Rezoning Transportation Analysis
Petition Number: Insert Zoning Petition #2022-030
General Location Identifier: 08311127

Revision Log:	Date	Description
	07-24-2022	First Review (AO)

800 MATHESON AVE - REZONING
 PARCEL ID 0811127
 800 MATHESON AV CHARLOTTE NC 28205
SITE PLAN - REZONING

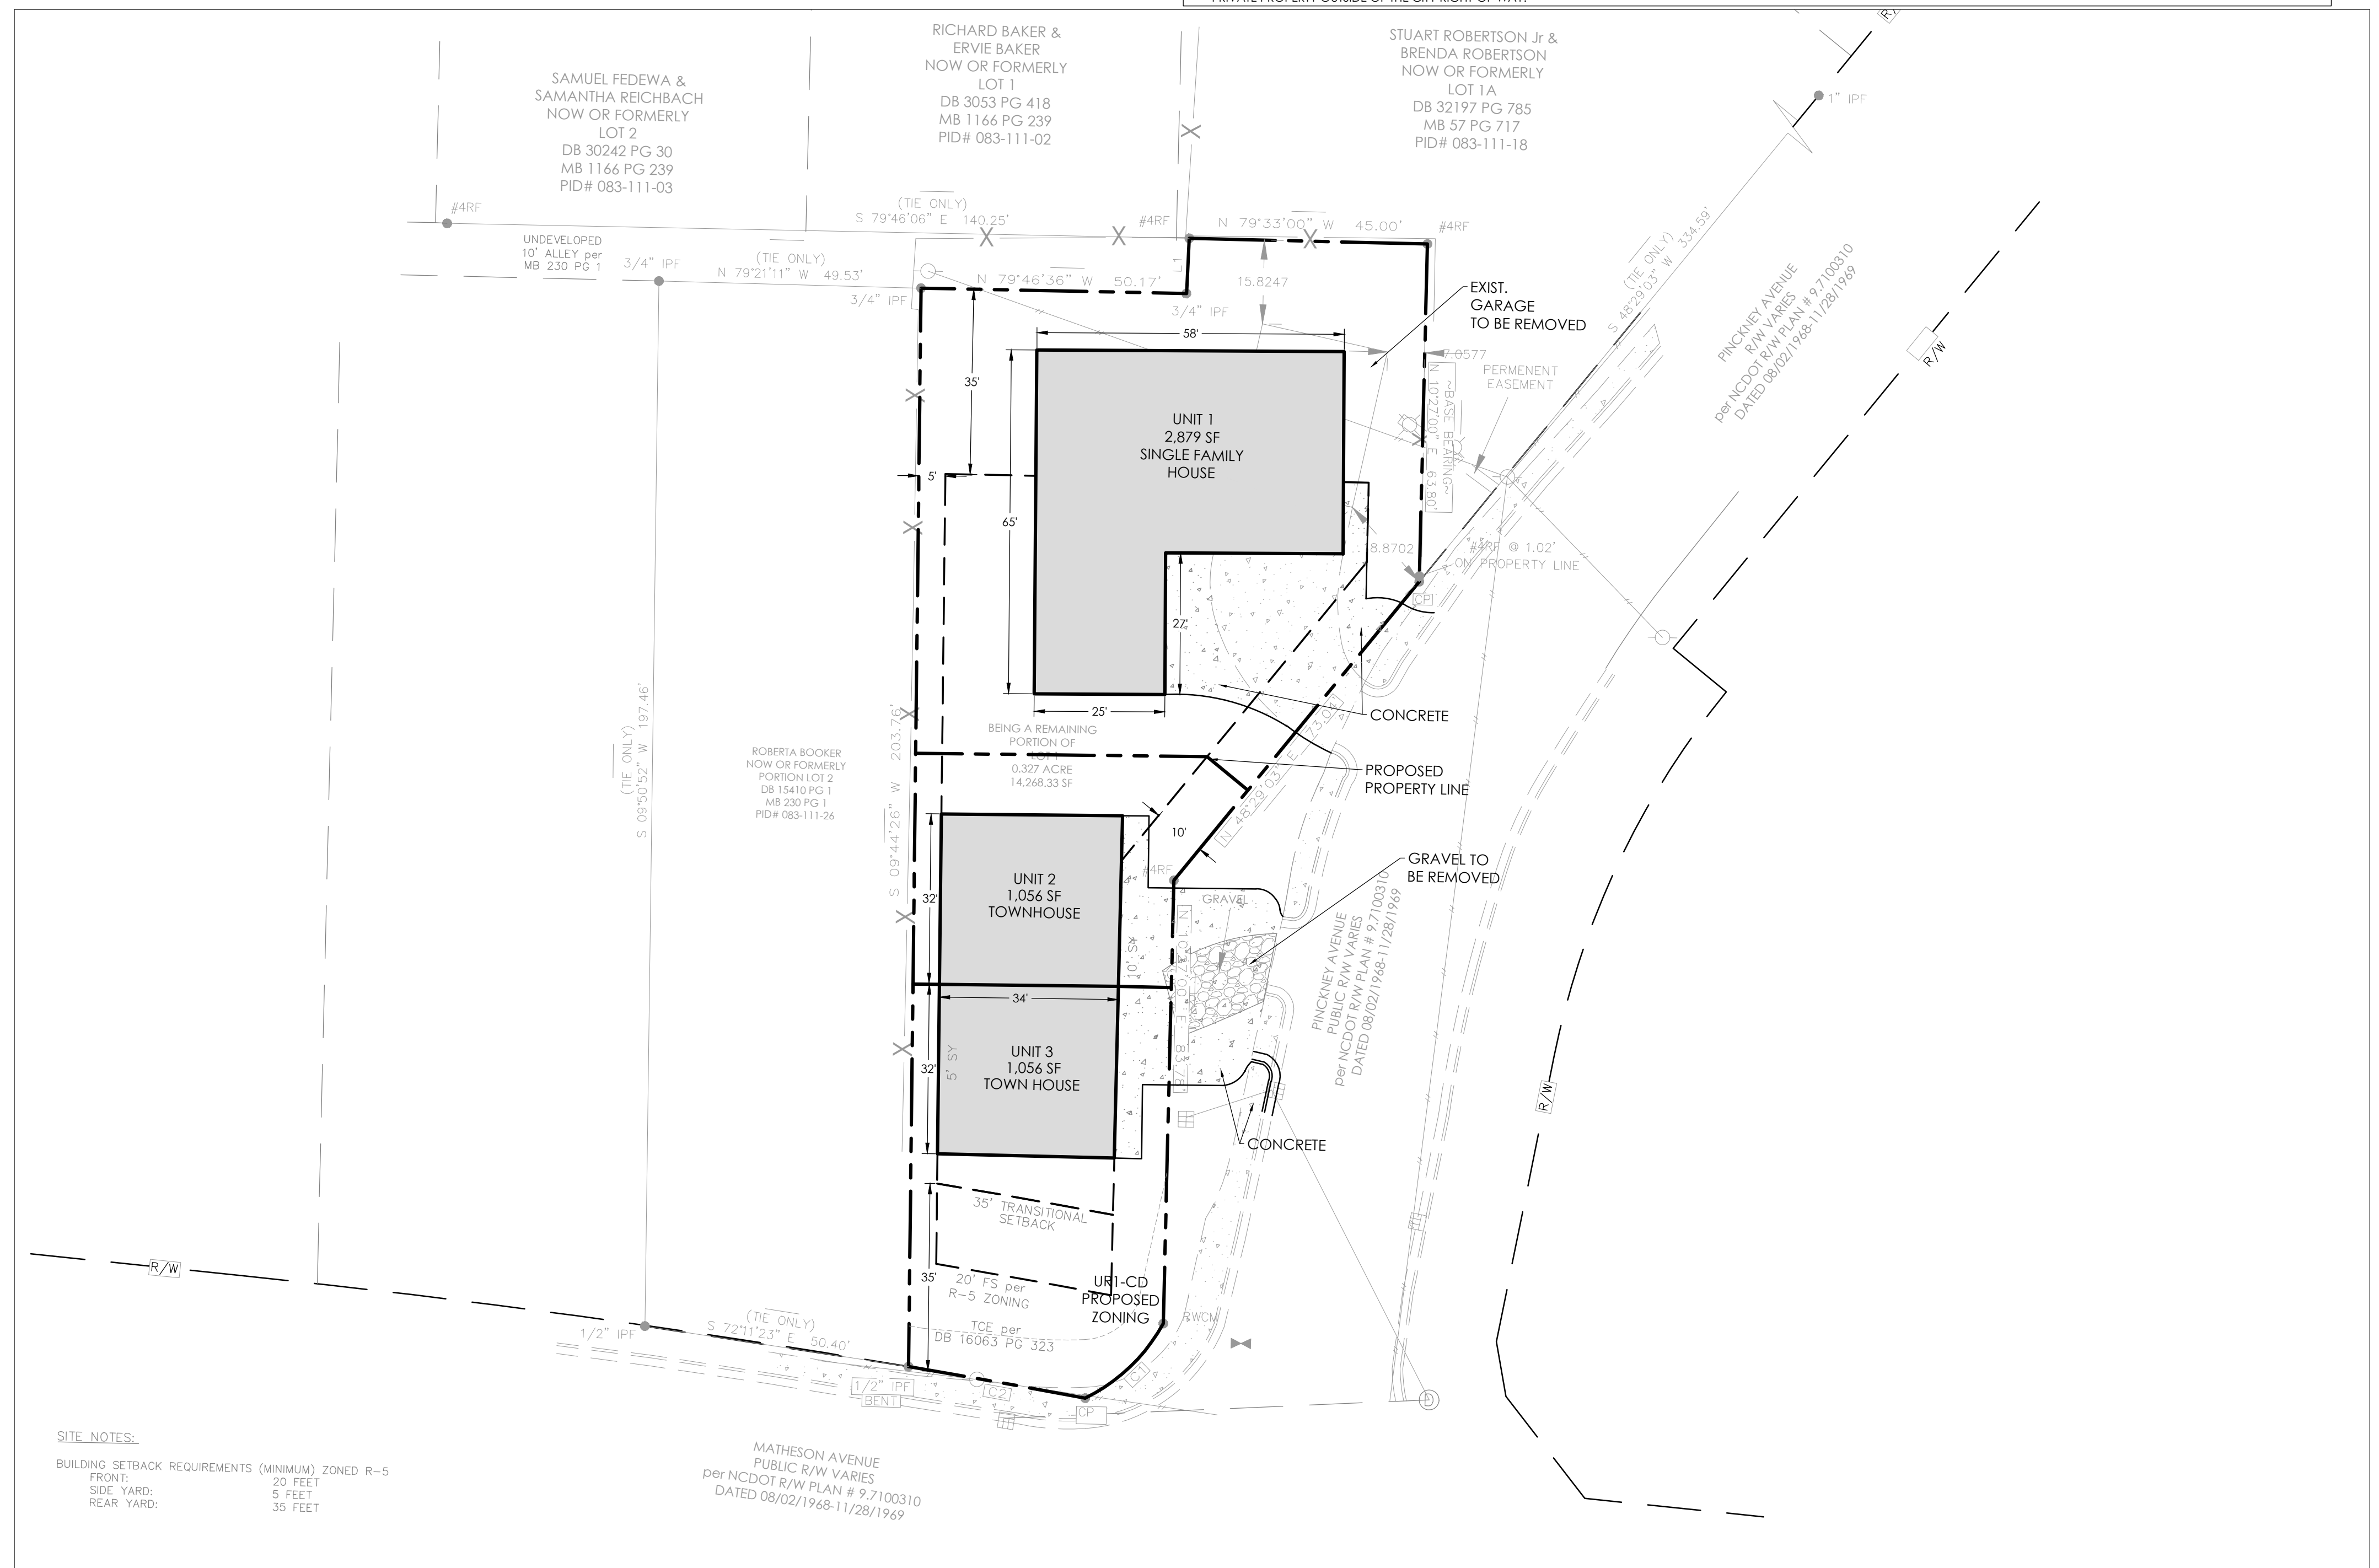
1. **Curblines:** The proposed zoning district has a setback measured from back of the existing or proposed future curblines.
 - a. **Matheson Avenue:** Curb and gutter to be 27-feet measured from centerline to back of curb .

Label and dimension the curb and gutter from the centerline for each road on the site plan.

3. Revise site plan and conditional note(s) to commit to dedicate 40-feet of right-of-way along Matheson Avenue measured from the road centerline. The site plan shall label and dimension the right-of-way from the road centerline.

4. Revise site plan and conditional note(s) to commit to construct an 8-foot planting strip, and 6-foot sidewalk on Matheson Avenue and Pinckney Avenue per Chapter 19. The site plan shall label and dimension both items from the back of curb and gutter.

5. Revise site plan and conditional note(s) to show proposed intersection and frontage improvements of Matheson Avenue Road Conversion project project that is being done by the City’s CIP project. These improvements can be shown as “by others” and in grayscale. The project scope includes converting Matheson Avenue from 4 lanes to 2 lanes, construct raised 2-way cycle track on south side of Matheson Avenue.

- 6. Revise site plan to verify adequate driveway storage to ensure a vehicle will not block the public right-of-way (Unit 2 and 3).
